Our reference: ECM 7091033
Contact: Mathew Rawson
Telephone: (02) 4732 7522

4 December 2015

Development Application (DA) (SSD 7075) and Environmental Impact Statement (EIS) for a proposed Resource Management Facility at 85-87 Quarry Road, Erskine Park, NSW (Lot 1 DP 1140063)

1 EAST ELEVATION
1 : 250

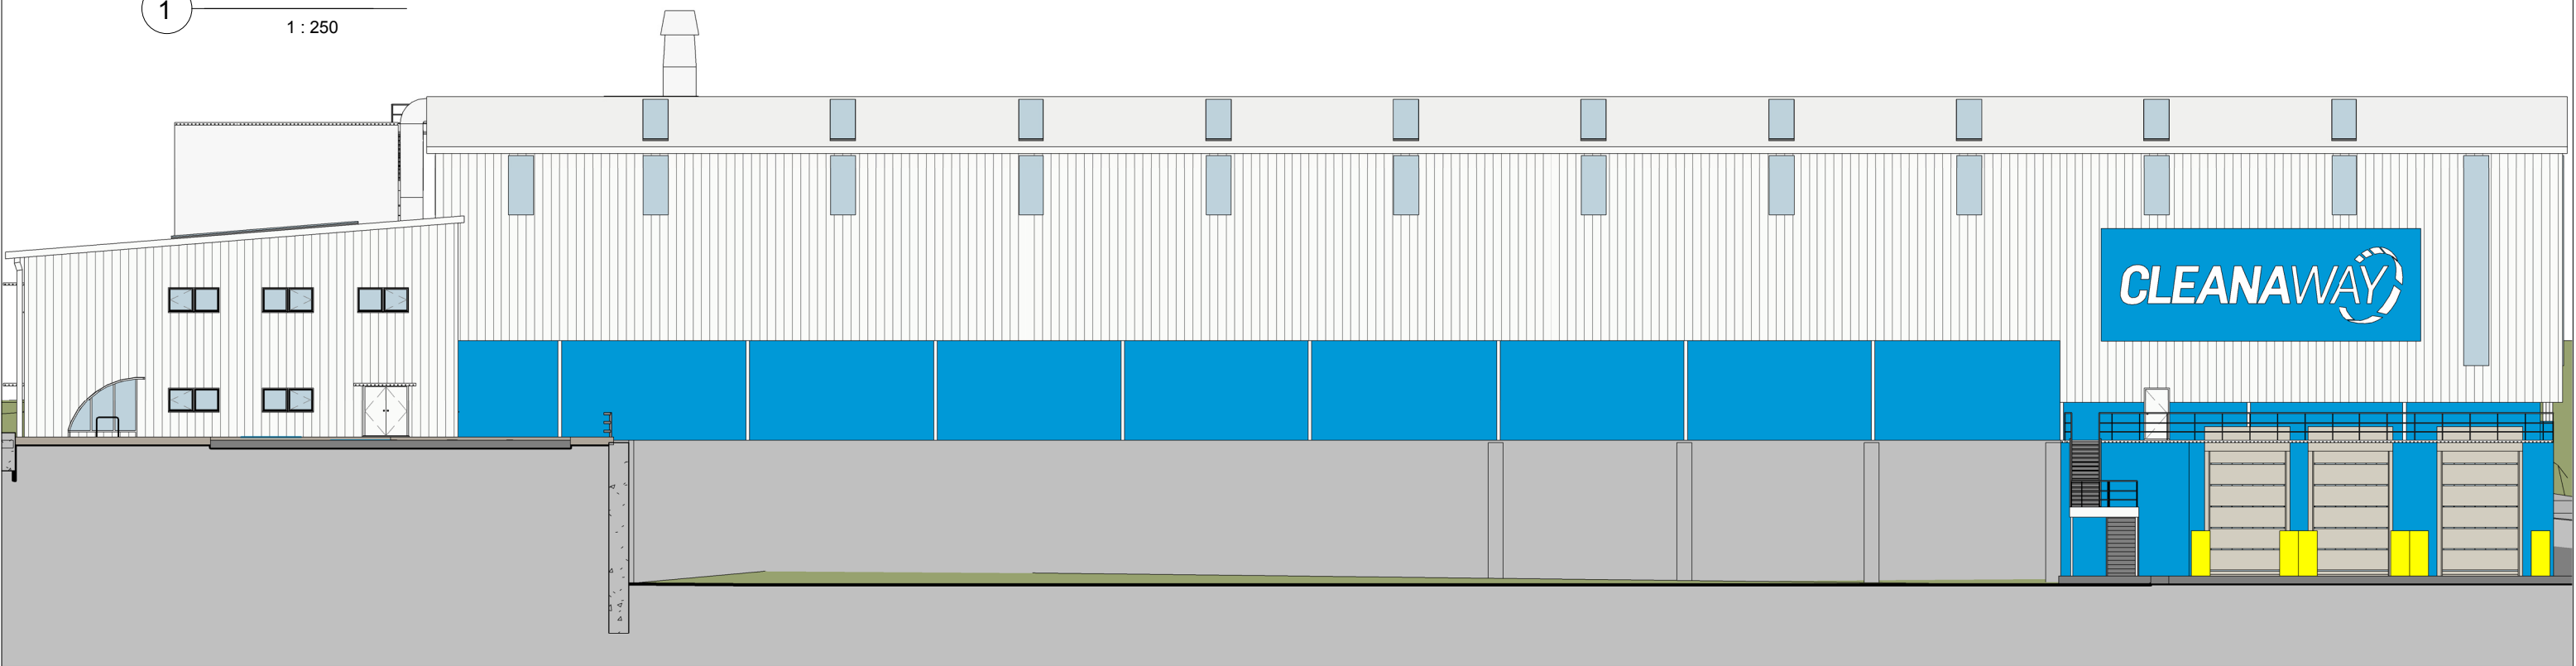
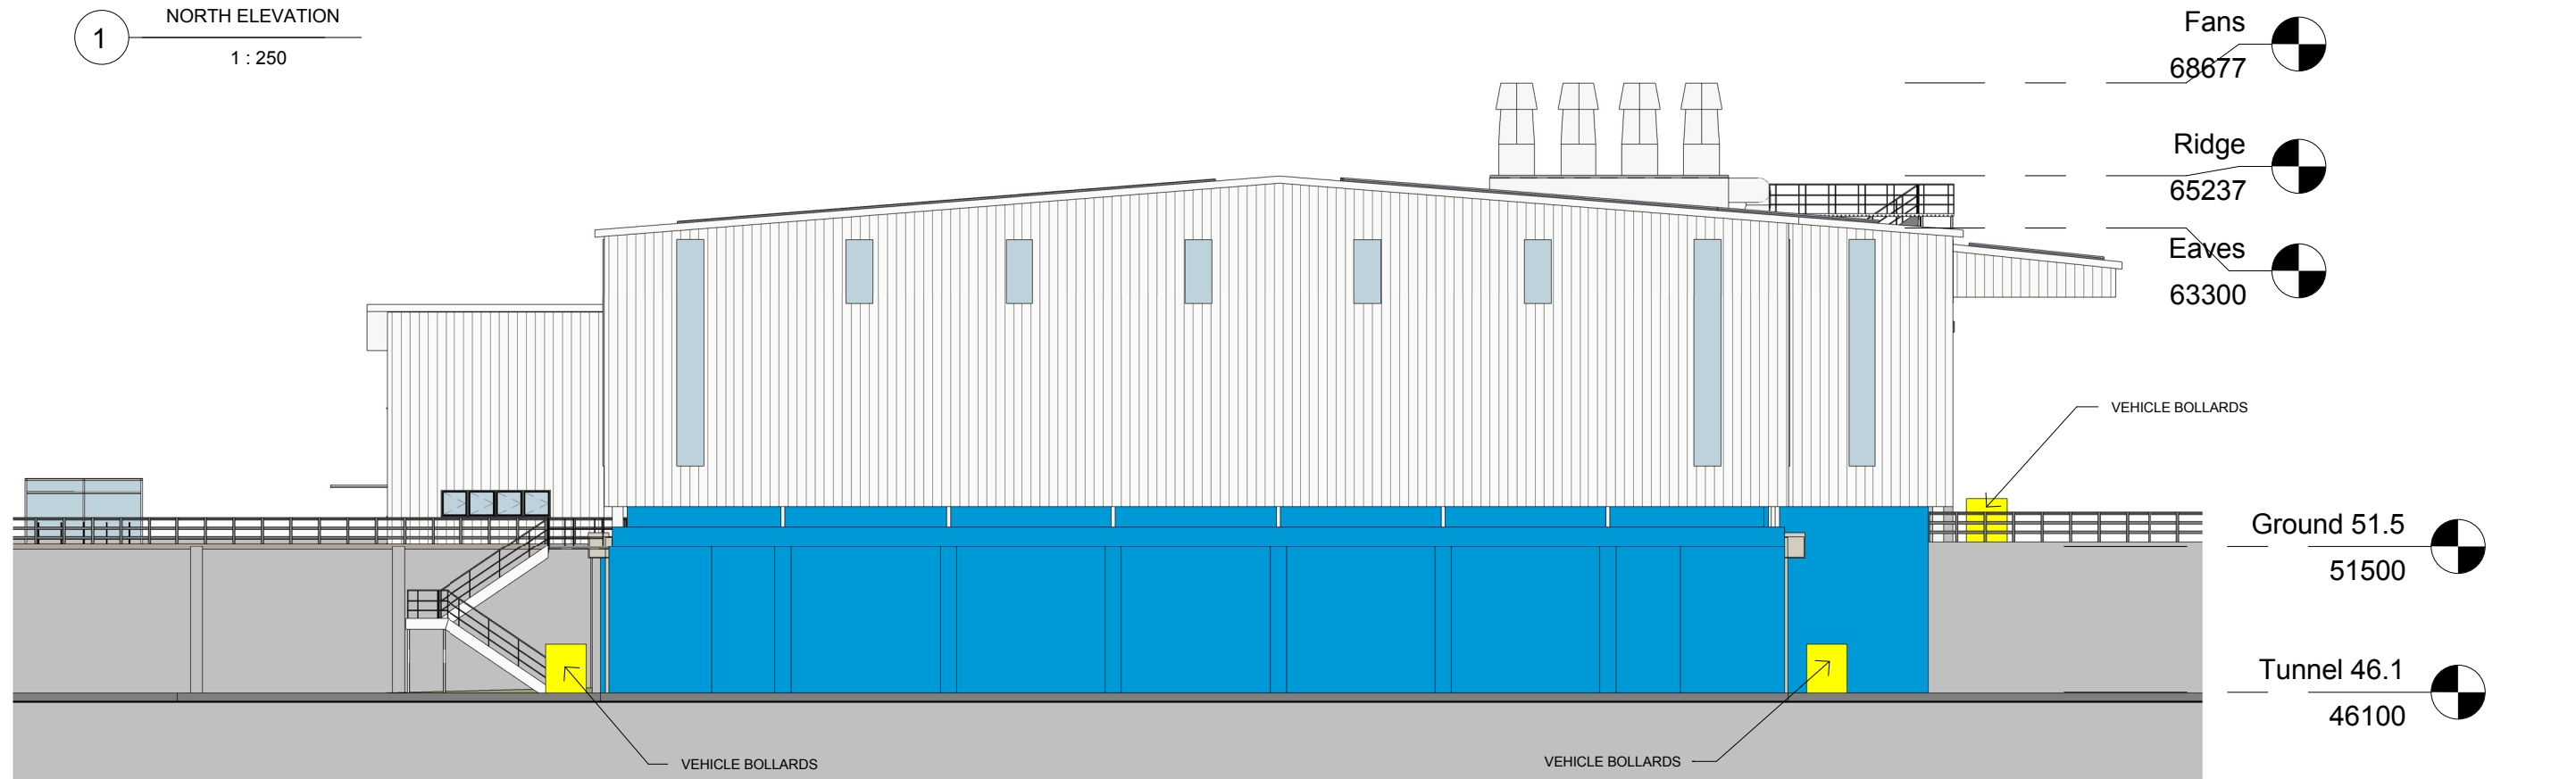
Greater articulation and architectural treatment is required. The use of colours, materials and additional articulation through projecting elements and parapets to roofs is suggested to achieve this. Additionally the use of a central office/staff break room/main entrance may be used as a focal point of the design which incorporates different materials, proportions and colours. Entrances should be distinguished for example through the use of awnings and/or colour. The use of exposed frames and oversized elements such as downpipes can be used to create visual interest.
